TfNSW reference: REN25/00086/005

Your reference: SSD-72430958

**SSD-72430958, Finley Battery Energy Storage System - Various Lots, Berrigan Shire Council;
Response to Submissions**

This attachment relates to TfNSW's response dated 2 April 2026 reference REN25/00086/005.

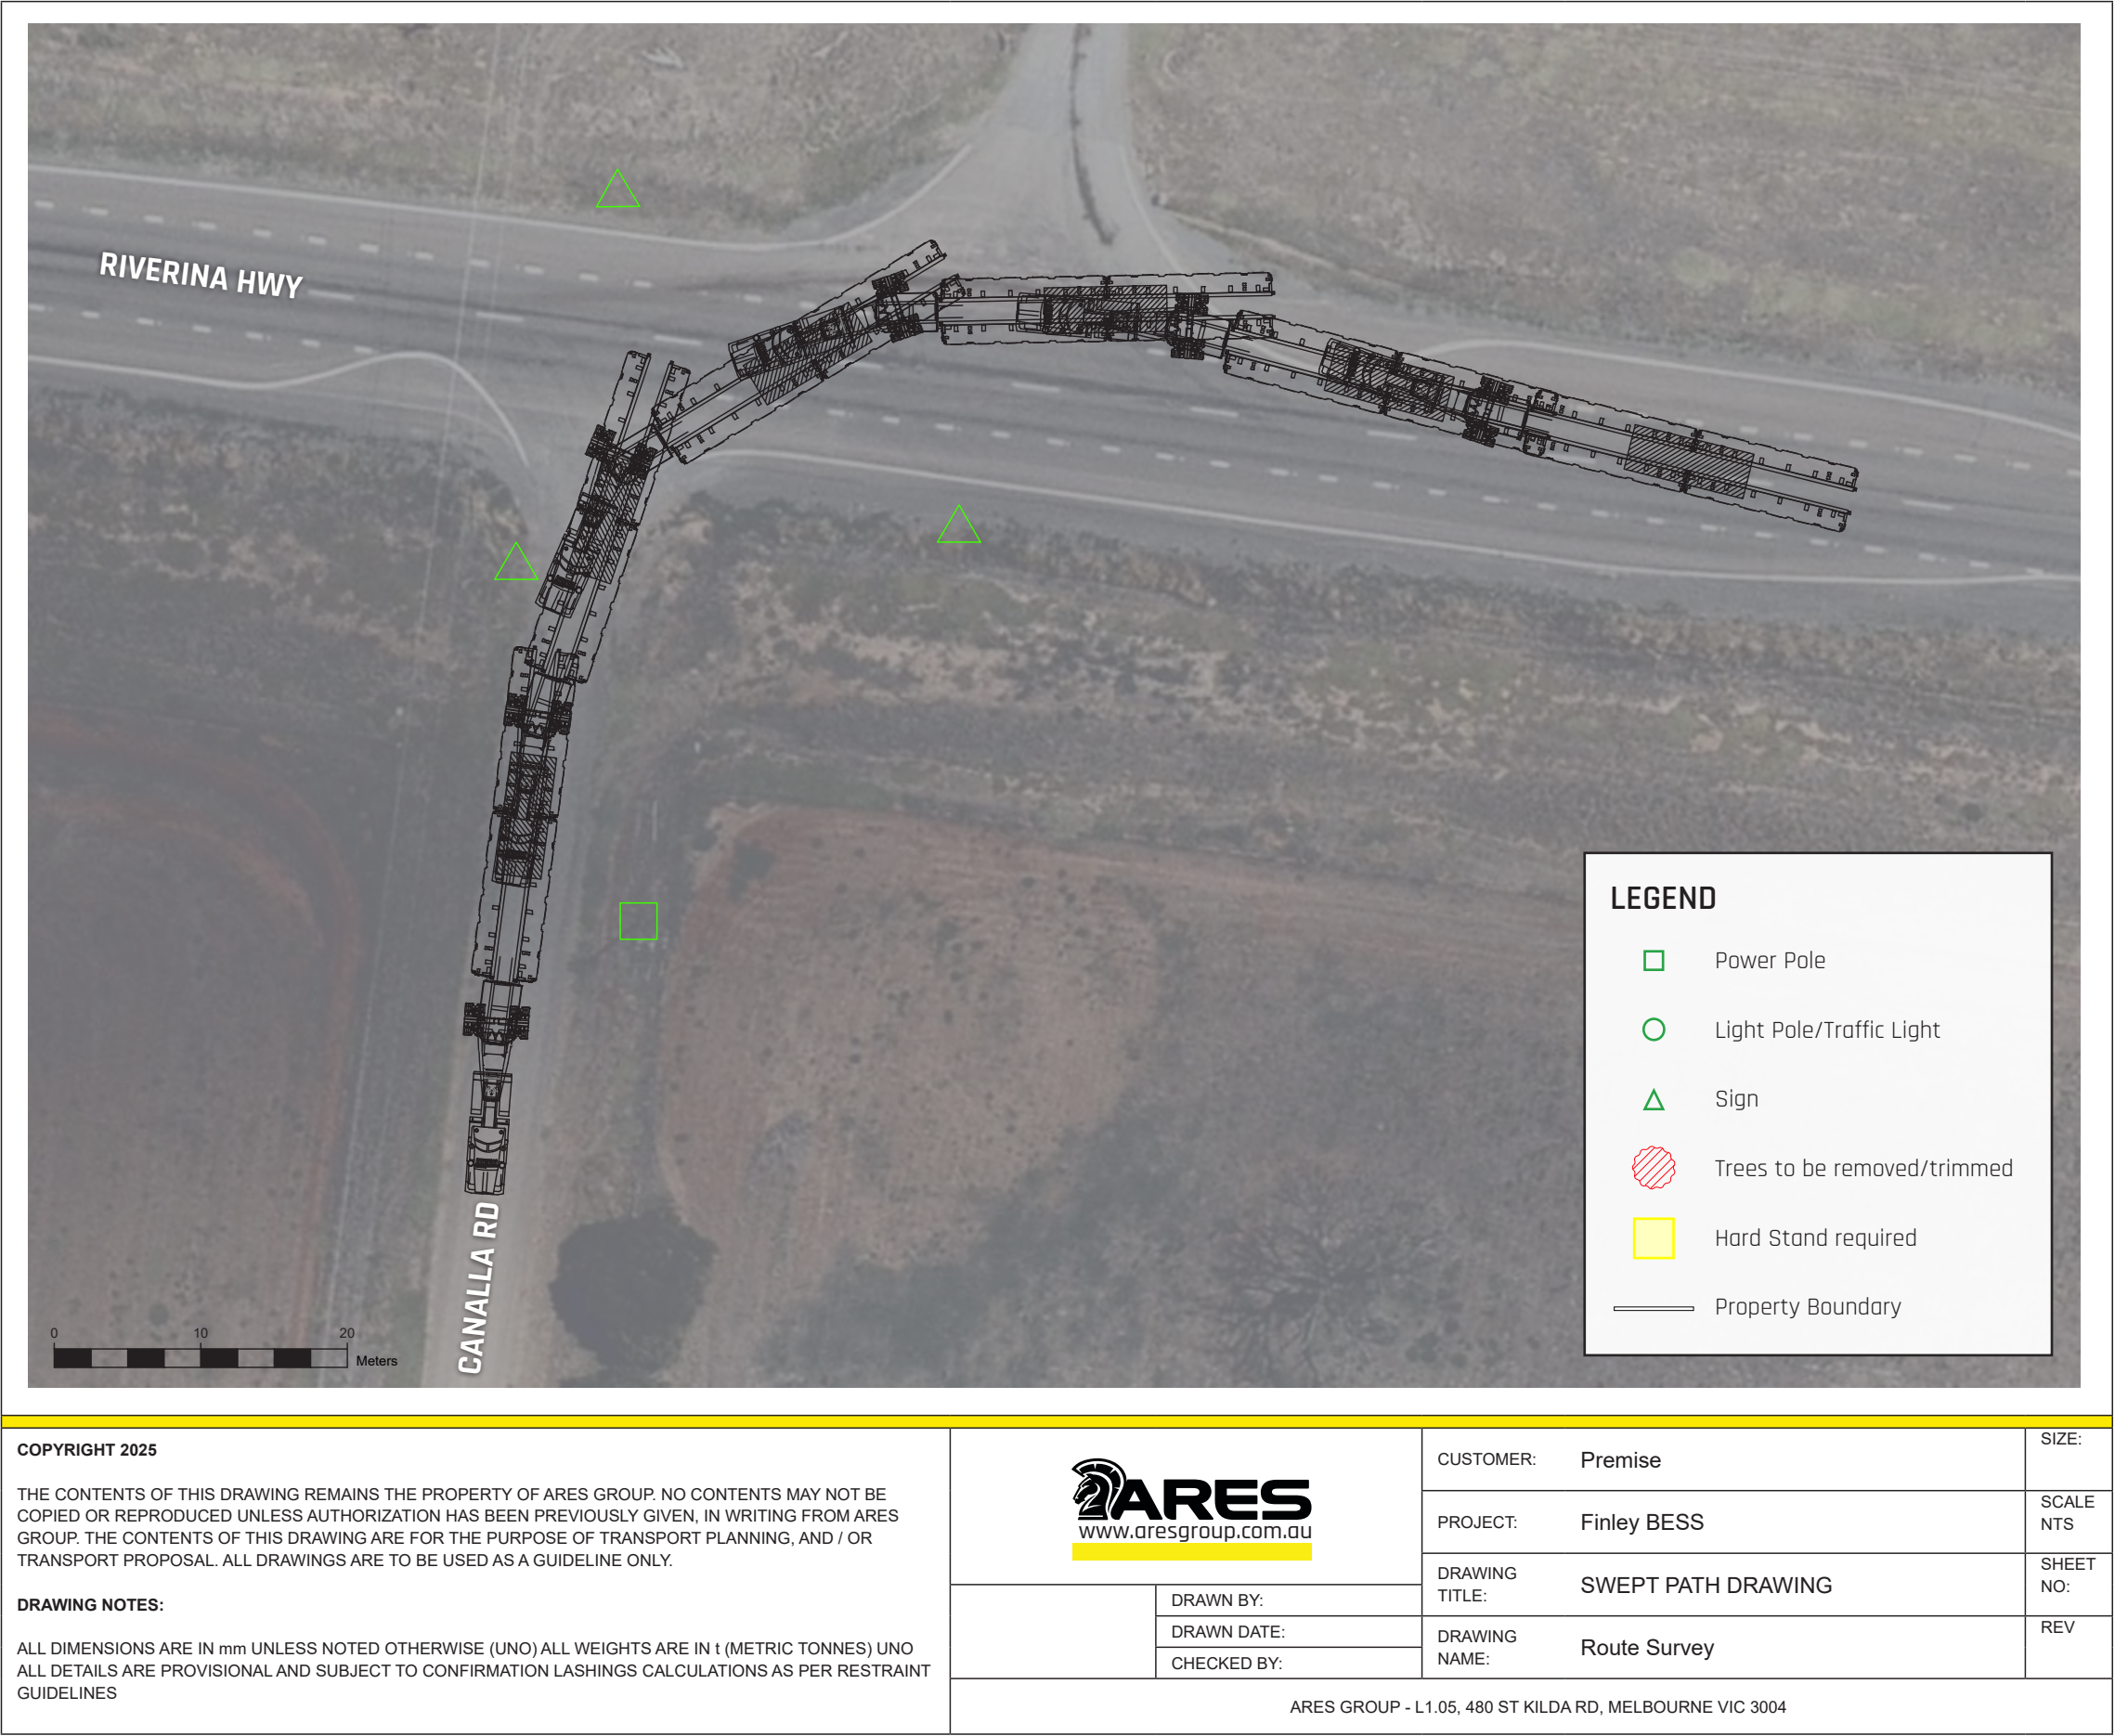
d) Swept Paths Swept paths are required to be provided for the largest heavy vehicle and high-risk OSOM configuration (corresponding to the design and check vehicle) required to use each intersection, access point or navigate pinch points along the high-risk OSOM routes. This must be prepared following Austroads Design Vehicles and Turning Path Templates.	OPEN - The swept path still shows a right-turn movement crossing the Canalla Road centreline. Revise the swept path analysis and consider traffic mitigations to manage the impact to avoid crossing the centreline of Canalla Road. If traffic mitigation measures (i.e., limiting the use of the intersection for construction traffic to one heavy vehicle at a time, turn prohibitions or reduced design vehicle size). The implementation of traffic mitigation measures, enforceability and compliance must be discussed with DPHI to determine the suitability of the proposed measures. If DPHI determines that the proposed traffic management measures are not enforceable, the intersection will need to be widened to accommodate concurrent turn movements within the pavement, without requiring crossing the centreline of Canalla Road.

C001

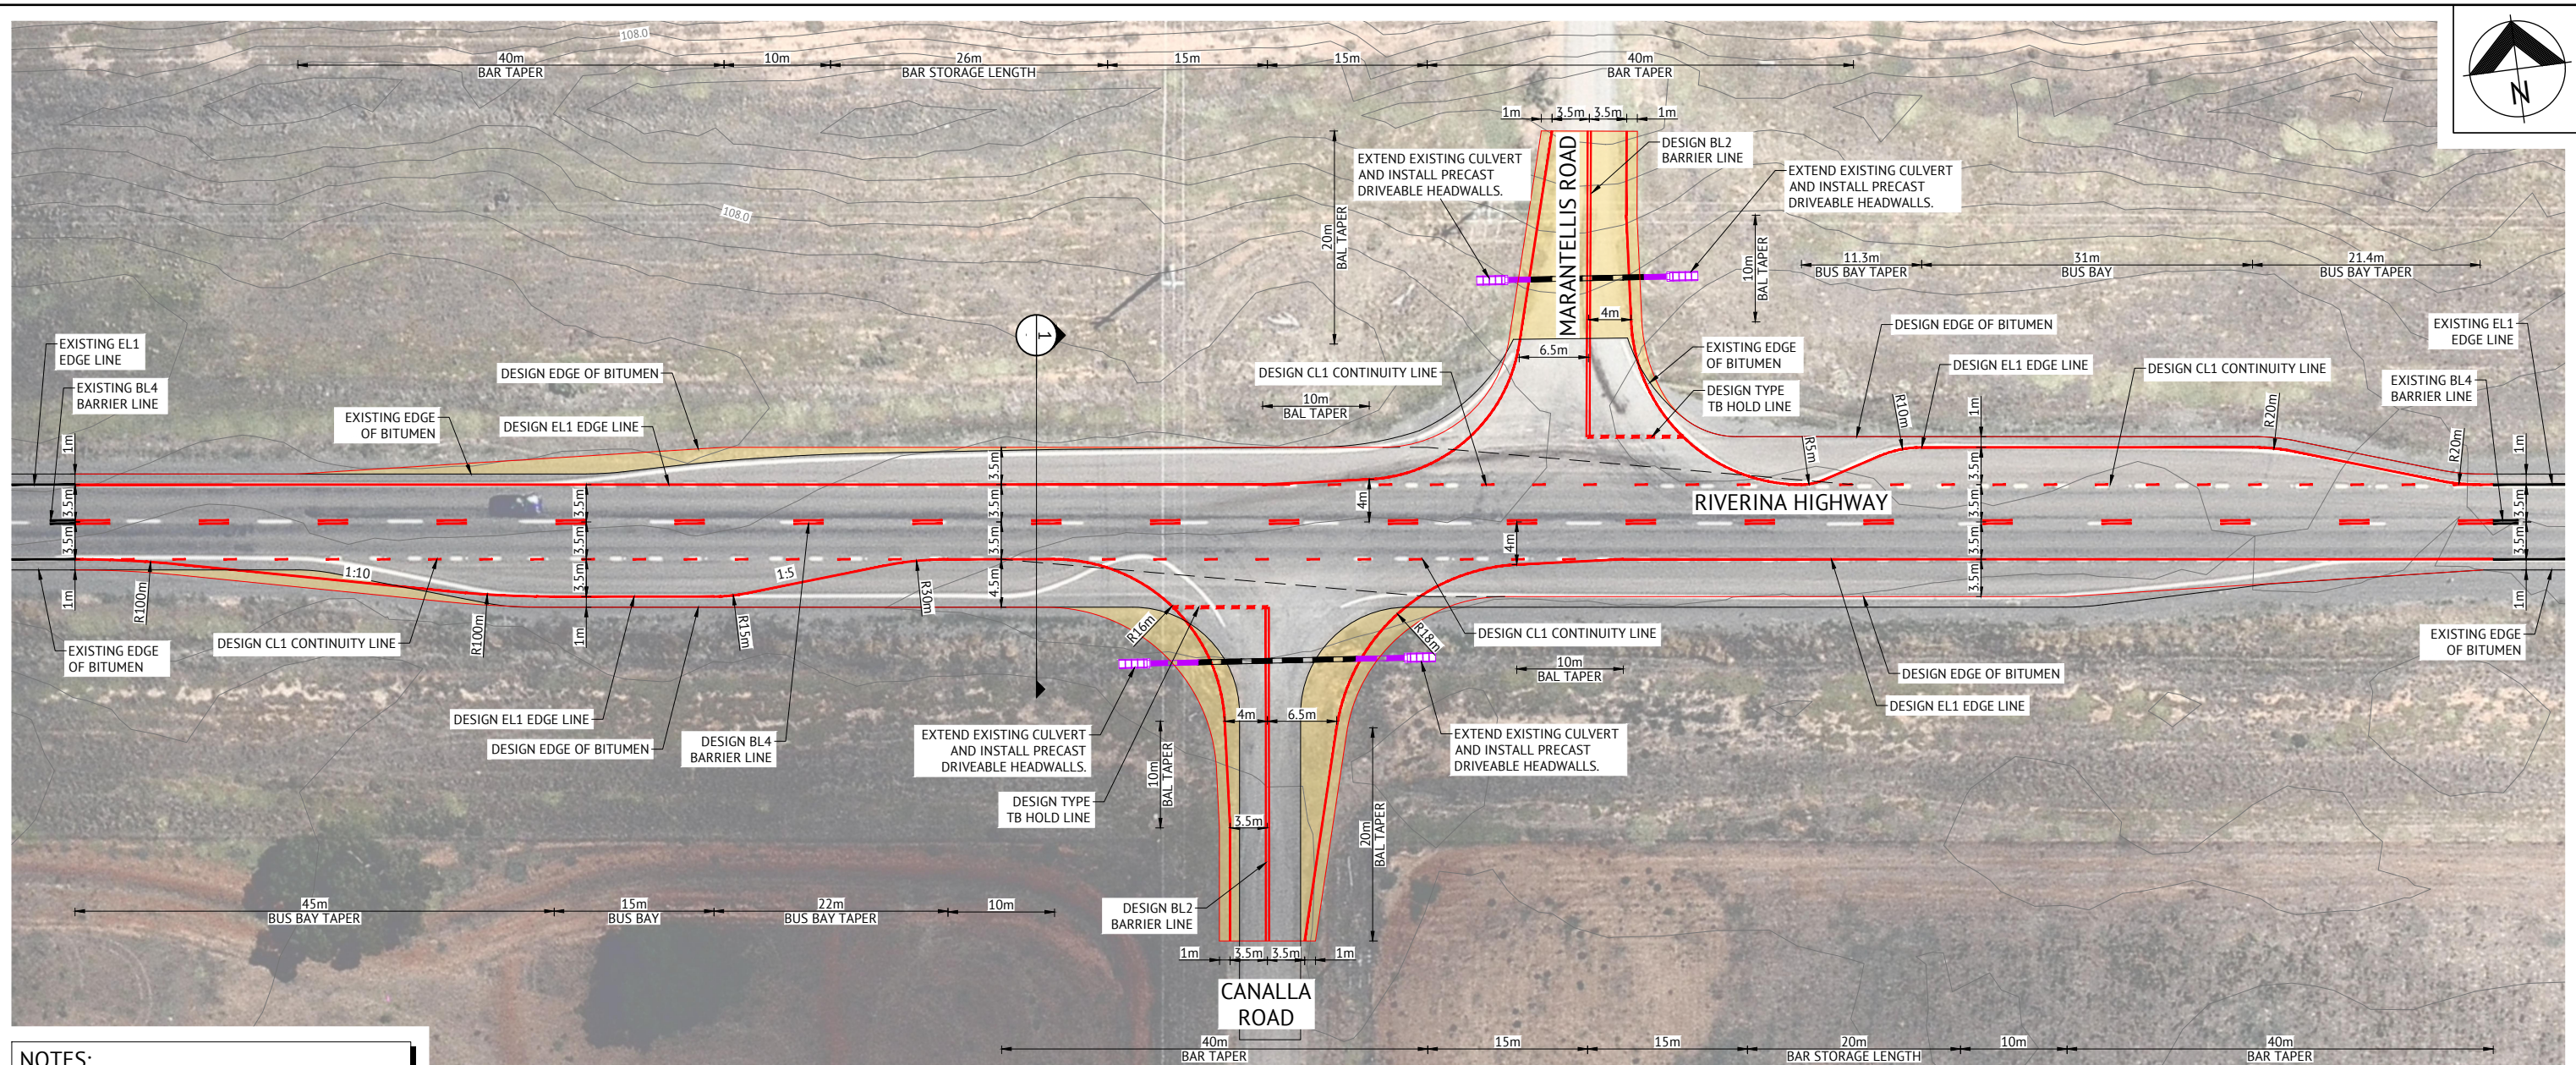
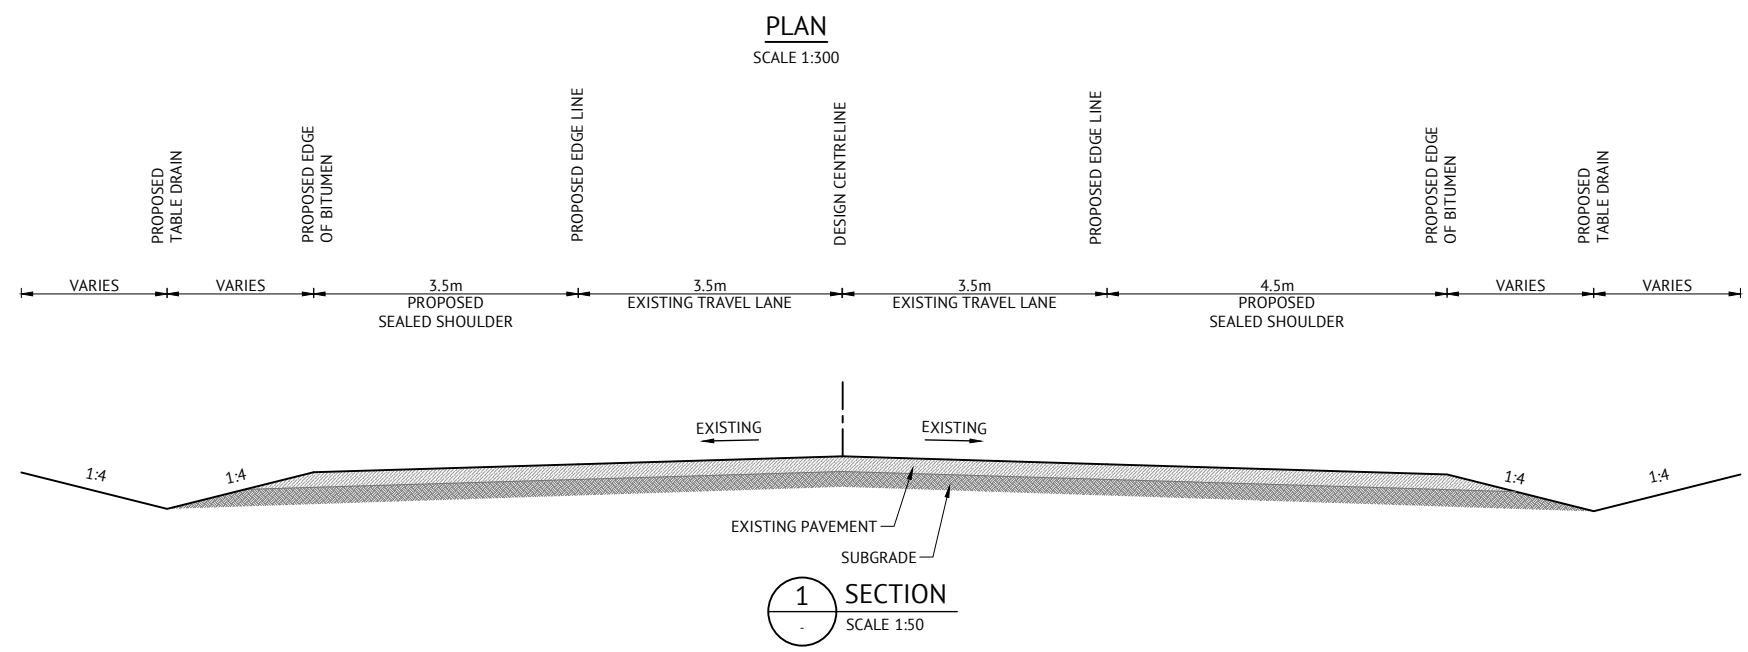
Key issue 2: Issues with utilising existing turn treatments The existing turn treatments are deficient. The proponent is to provide strategic concept designs that demonstrate compliance with Austroads Guide to Road Design, Part 4A. The project intersection strategic designs must be updated based on the outcome of the updated analysis and to ensure that the largest vehicles using the intersection can be accommodated within the pavement. TfNSW requires the following matters to be addressed in the response to submissions. a) Issue with using the existing Auxiliary Left Turn treatment (AUL) - Canalla Road / Riverina Highway The proposal intends to rely on the existing treatments at the intersection of Canalla Road/Riverina Highway. Review of the AUL(s) on Riverina Highway to facilitate a left turn does not comply with Austroads. It will not be able to cater for the increased traffic and design vehicles based on the existing deficiencies, as the AUL(s) does not comply with the length and width requirements for an AUL(s) and do not include sufficient arrow line markings. Strategic concept designs will be required for the upgrade of the deficient AUL(s) that demonstrate the scope of the upgrades needed for the AUL(s) to achieve compliance with Austroads. Refer to advisory notes for specific references to Austroads concerning this point.	OPEN – A number of design issues have been raised in the sections below that still require modification in the proposed strategic design. Please review and make the amendments and provide them in the updated TIA. Proposed plans demonstrate a v-drain; however, TfNSW requirements clarify that a table drain is required to comply with Austroads and TfNSW supplements. Please amend the drains on the updated plan.

The Basic Right Turn treatment on Riverina Highway, which facilitates the right turn into Canalla Road, does not comply with Austroads. The increased traffic and proposed design vehicles will exacerbate the current safety issues with the non-compliant BAR. Strategic concept designs will be required to be submitted that demonstrate the scope of the upgrades necessary to the existing BAR to achieve compliance with Austroads and TfNSW requirements. The strategic concept designs will need to address the following specific non-compliances with the existing BAR:

i. BAR does not meet the minimum requirement for the situation whereby a road user is not allowed to enter a dedicated left turn lane to pass / navigate around a stored vehicle turning right into the side road. The proponent must design a compliant BAR intersection treatment and line mark the edge line at a constant 3.5m from the centerline to provide a widened shoulder to satisfy the requirement of a BAR. (AGRD Part 4A – Section 7) The re-design will impact the existing treatments to Marantellis/Riverina Highway. The proponent in their re-design will therefore, need to consider what an appropriate BAR treatment is for both the Canalla and Marantellis Road intersections with the Riverina Highway and ensure both roads have compliant treatments. Consideration to upgrading the intersection with opposing CHRs should be given by the proponent due to the unconventional existing intersection design.

OPEN - TfNSW have concerns with the potential for a right-turning vehicle stored on the Riverina Highway and a vehicle moving past them utilising the BAR widened shoulder and the increased potential for a side-impact type crash as a result of the intersection geometry. This issue is exacerbated by increased turning movements. This must be corrected at the strategic design stage. A Road Safety Audit will be required at detailed design.

ii. A hold line is to be included set back from the through edge line to hold side road traffic free of the widened shoulder to ensure the BAR intersection treatment will operate as intended. Austroads Figure 7.1 demonstrates requirements for a compliant hold line setback. The setback should take into consideration the unconventional design of the road.

OPEN – TB1 line marking is still required to be demonstrated on strategic plans.
